Application No: AW/81/21/HH
Site Address: 2 Old Farm Close Aldwick PO21 4AX
Description of works: Two storey extension.

Thank you for your internet representation made on 17th April 2021 which has been recorded as an objection with the comments as follows:

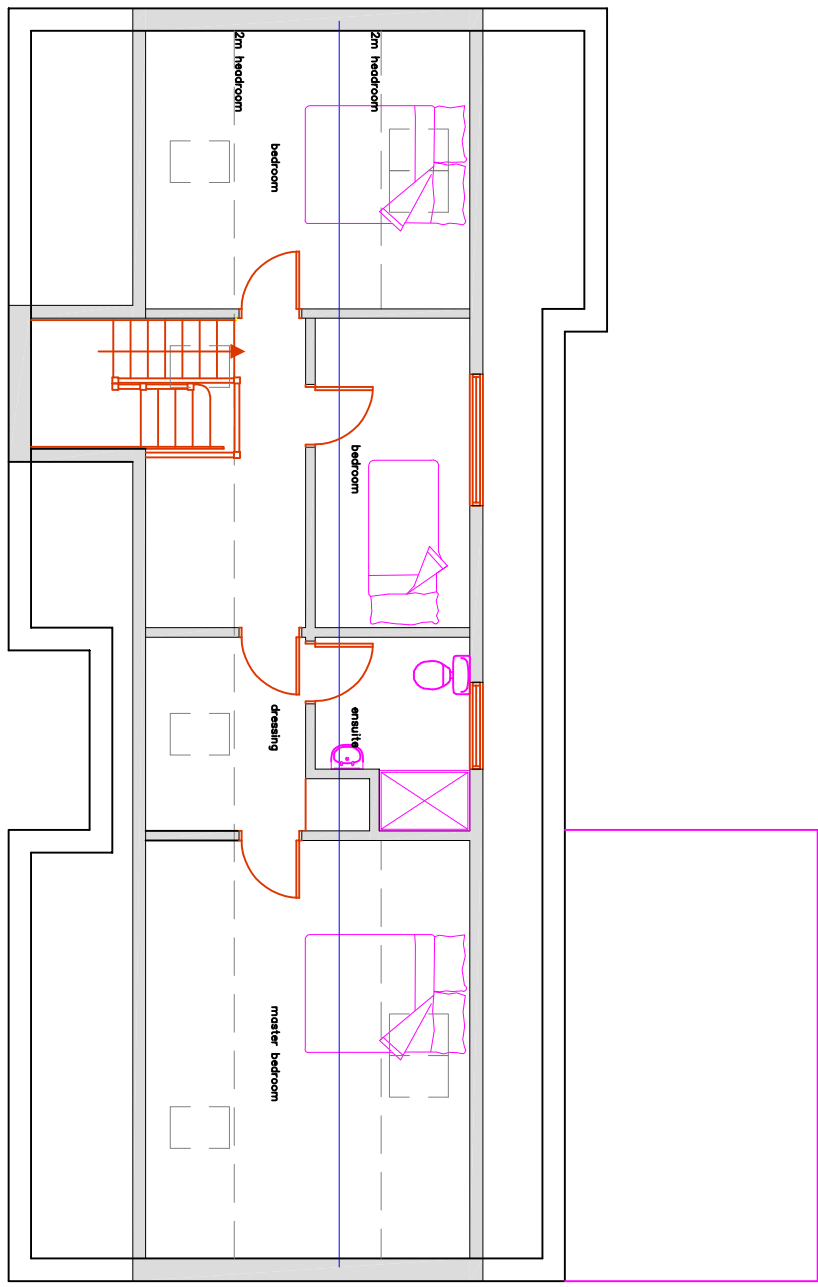
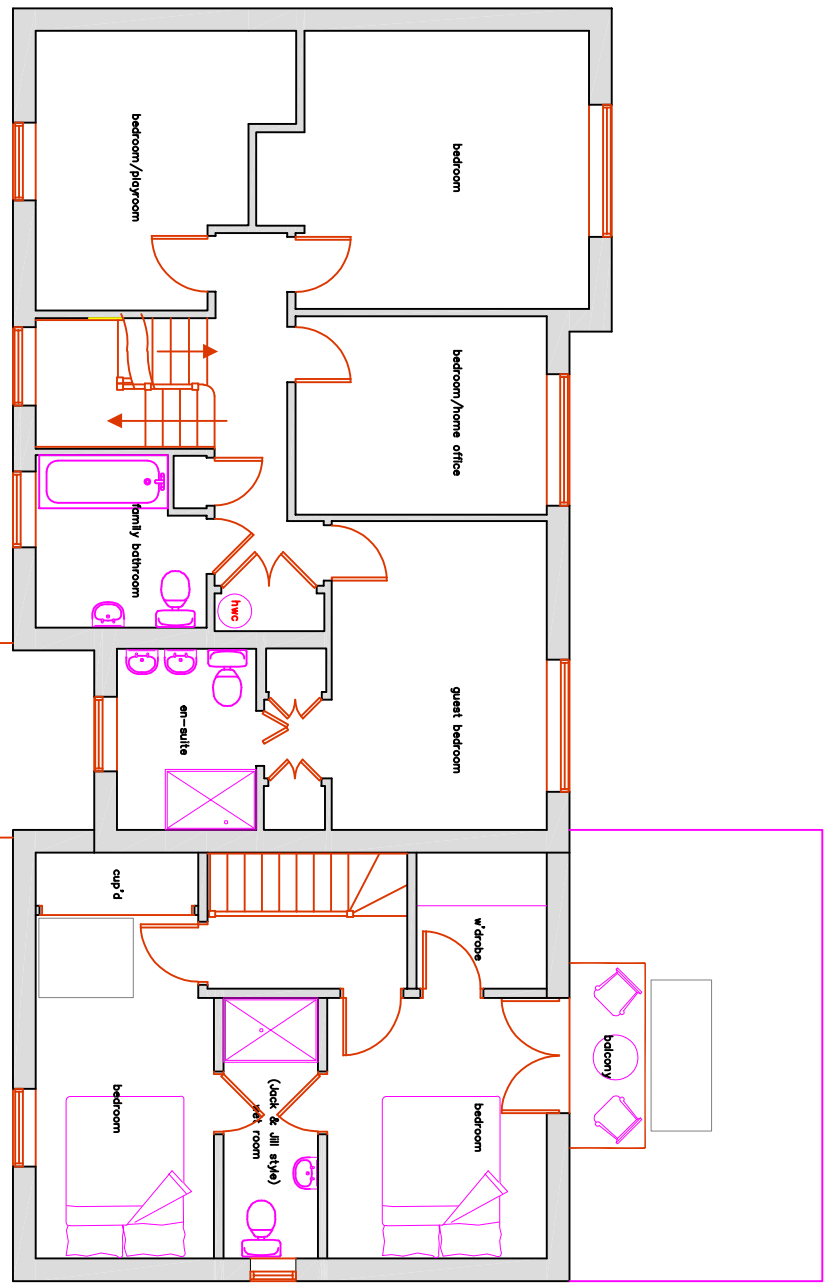
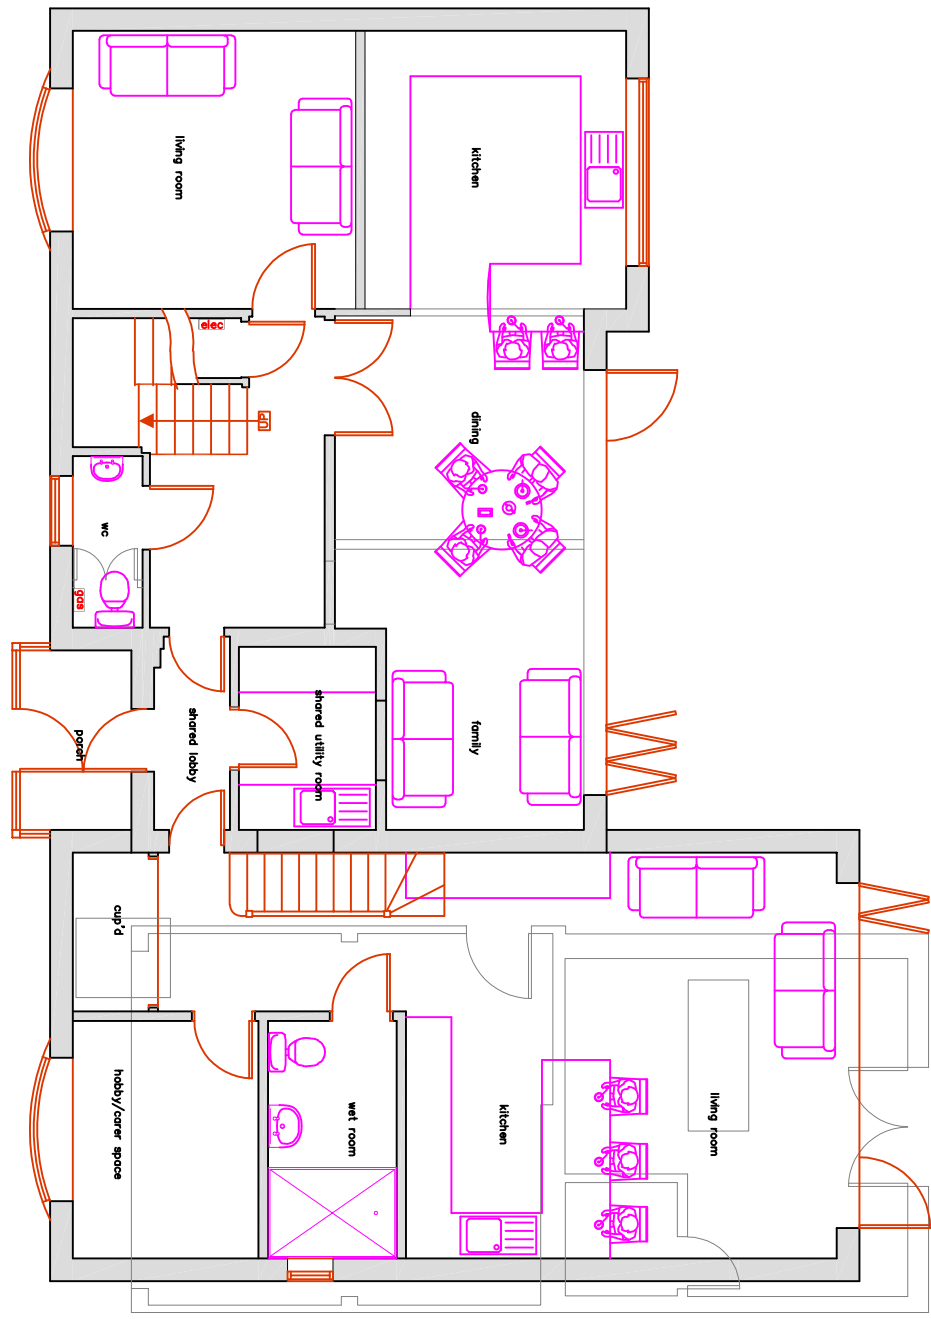
The applicant seeks to justify the proposed development to accommodate a single dependant relative, and whilst sympathetic to the applicants care needs, the proposed works incorporate 5 additional bedrooms, including 2 in the annex plus a 'hobbies/carers' room making 9/10 bedrooms in total, increasing the habitable space by over 100%, with no garage space. The internal space would far exceed the space appropriate to the requirements of all occupants both now and in the future.
